Town & Country Planning Act 1990 (as amended)
Town & Country Planning (Tree Preservation) (England) Regulations 2012

Application No: FG/217/21/T
Site Address: 1 Sea Lane Close Ferring BN12 5DT
Description of works: 1 No. Macracarpa tree (T1)- Remove damaged major lower N/E limb back to trunk.
Reduce lower northern limb by 3m to give adequate distance from highway.
Reduce radial spread by 2m, reduce overall spread from 14m to 10m. Crown lift to 5m. Deadwood canopy and remove any damaged branches.

Thank you for your internet representation made on 4th January 2022 which has been recorded as an objection with the comments as follows:

T1

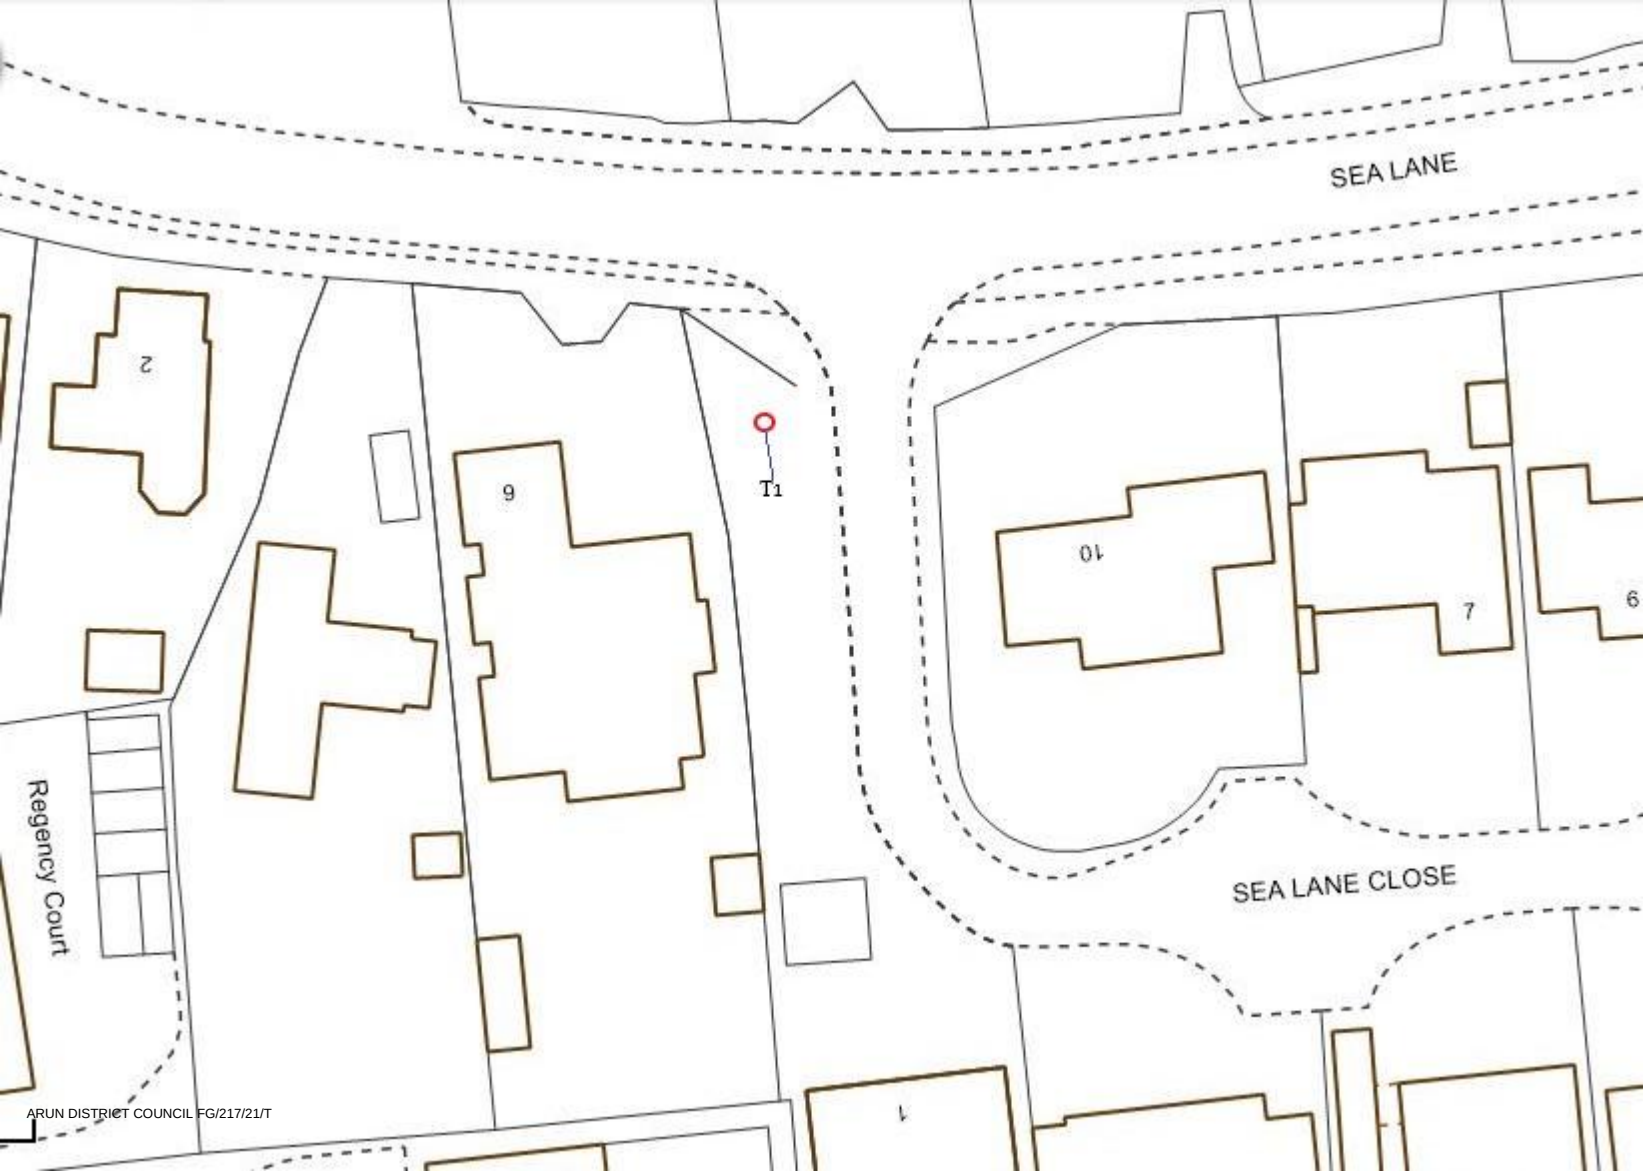
The Parish Council agrees with reducing radial spread to north by 2m but not to reducing overall spread from 14m to 10m that would be damaging to tree. Crown lift to 5 is excessive and 3 to 4m would be acceptable. Removing deadwood and dangerous branches can normally be carried out without permission.

In summary, Ferring Parish Council objects to this application and to the reducing of overall crown spread and crown lifting to 5m as being excessive and damaging.
